Ribble Valley Borough council
By email

Your ref: 3/2022/0176
Our ref: DC/22/1057 v2
Date: 24-MAY-22

Location: Lidl Shawbridge Street Clitheroe BB7 1LZ

Proposal: Extension of the existing food store and the provision of nine staff car parking spaces

Proposed Drainage Strategy (1:200)

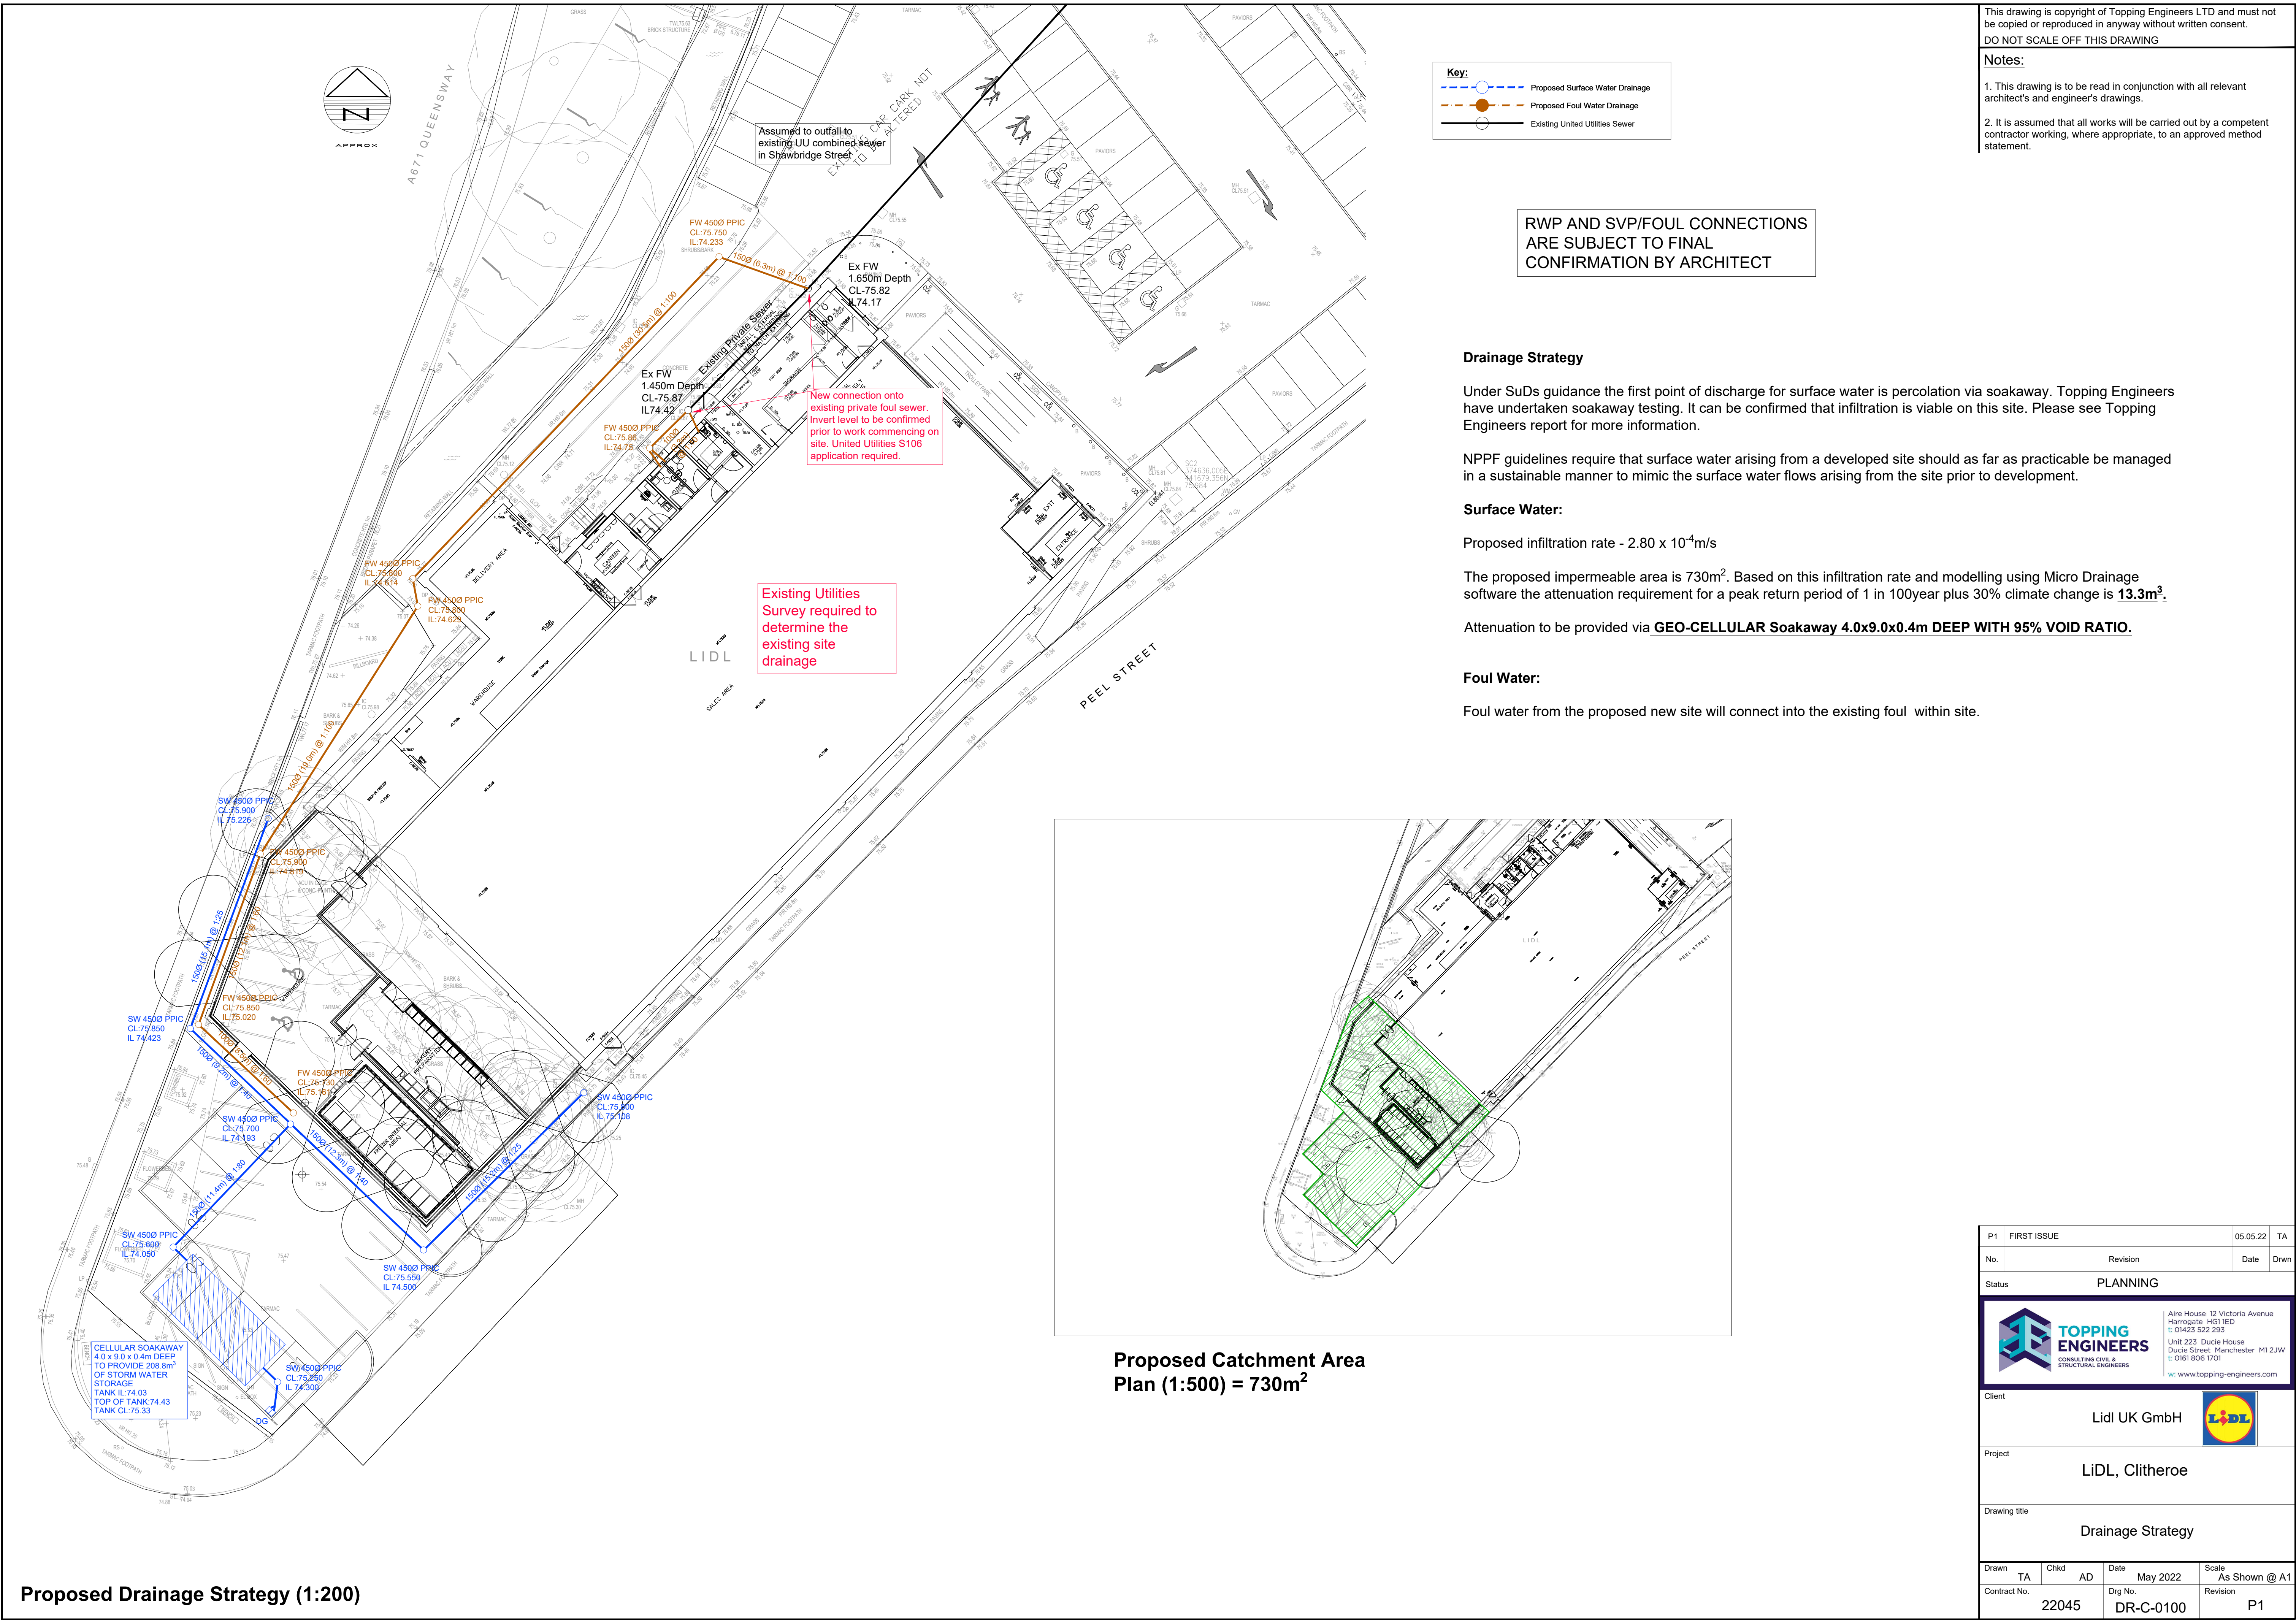
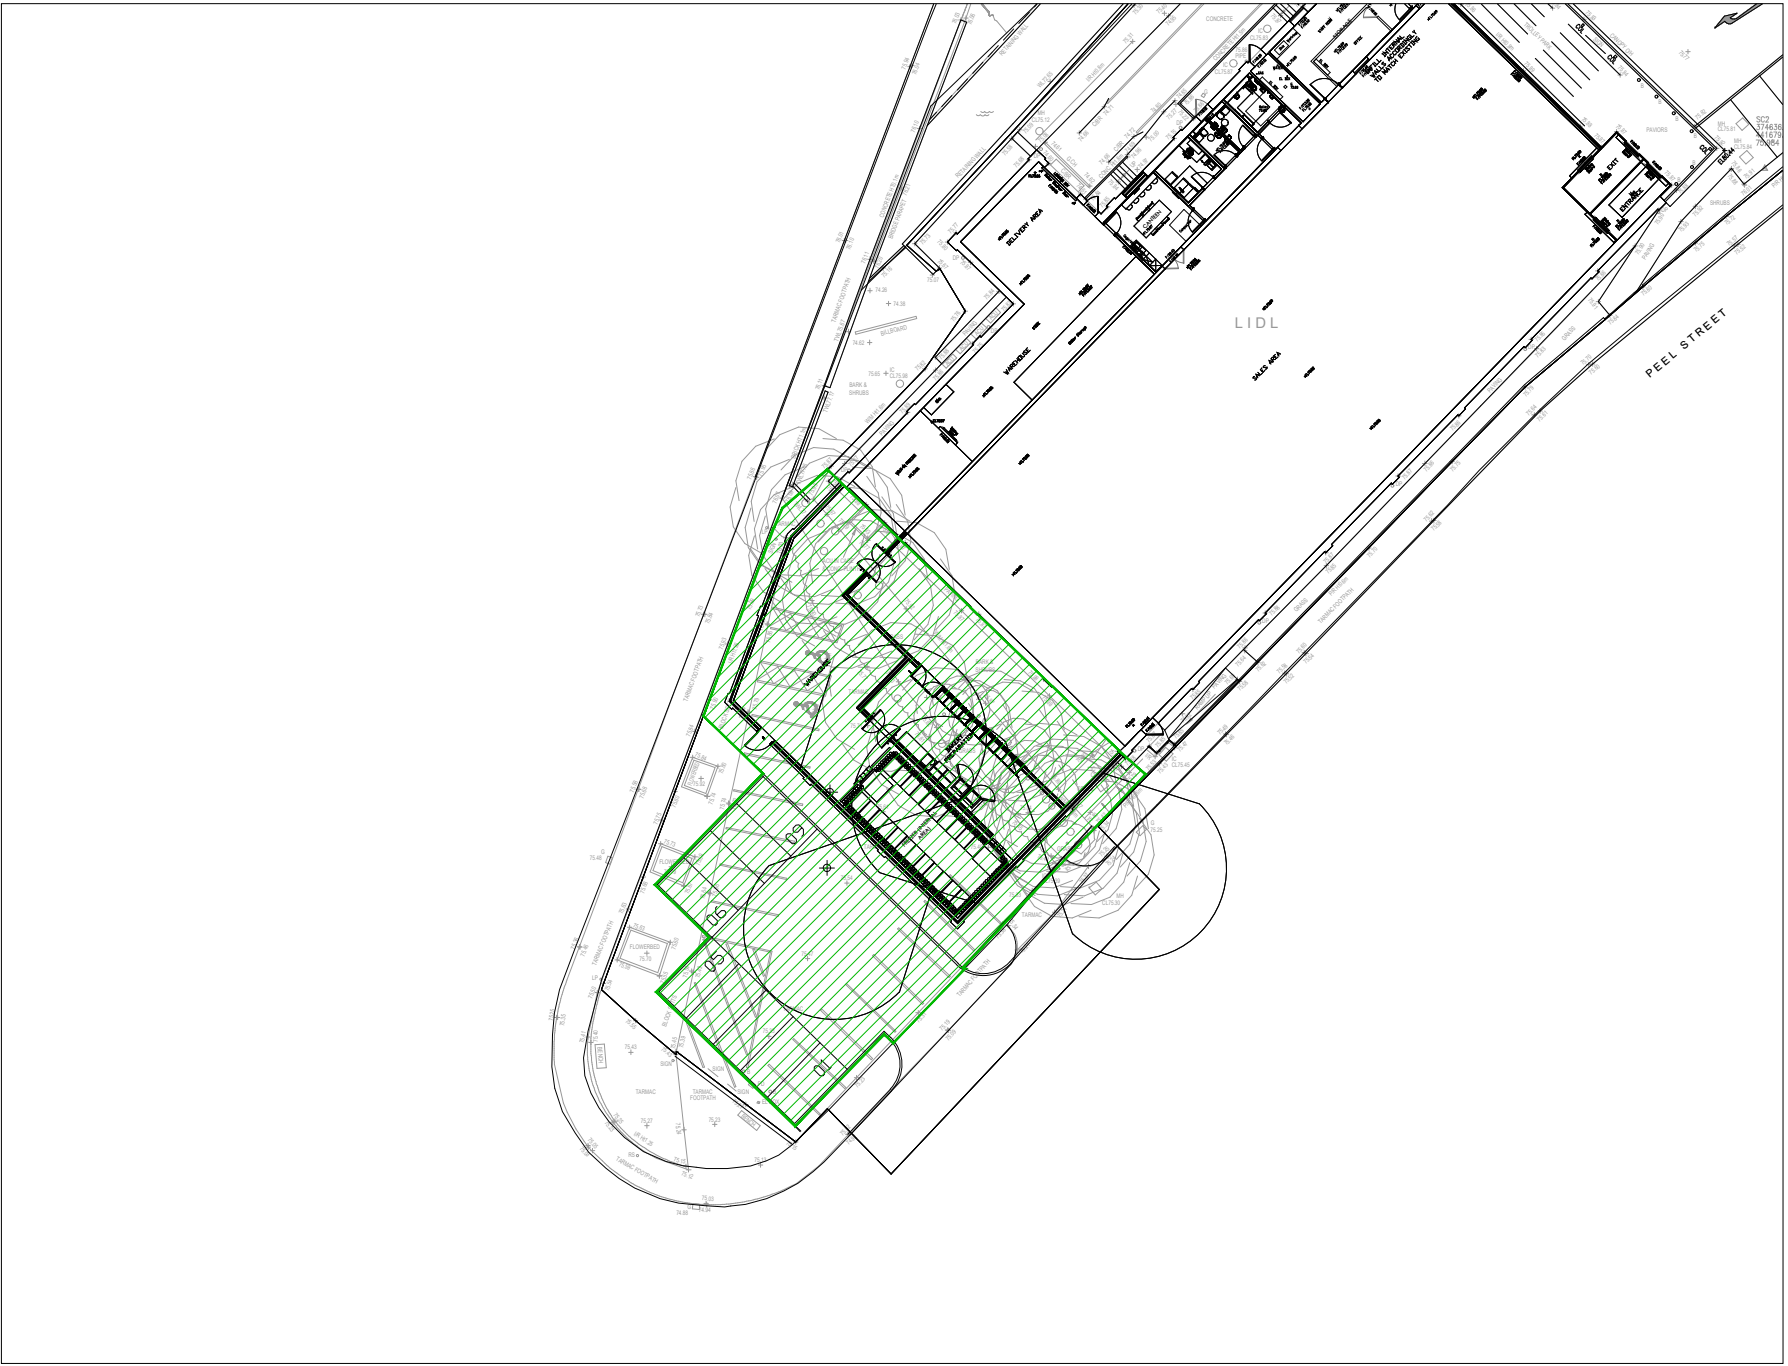
Following our review of the submitted Drainage Strategy, we can confirm the proposals are acceptable in principle to United Utilities and therefore should planning permission be granted we request the following condition is attached to any subsequent Decision Notice:

The drainage for the development hereby approved, shall be carried out in accordance with principles set out in the submitted Foul & Surface Water Drainage Design Drawing DR-C-0100, Rev P1 - Dated 05/05/2022 which was prepared by Topping Engineers. No surface water will be permitted to drain directly or indirectly into the public sewer. Prior to occupation of the proposed development, the drainage schemes shall be completed in accordance with the approved details and retained thereafter for the lifetime of the development.
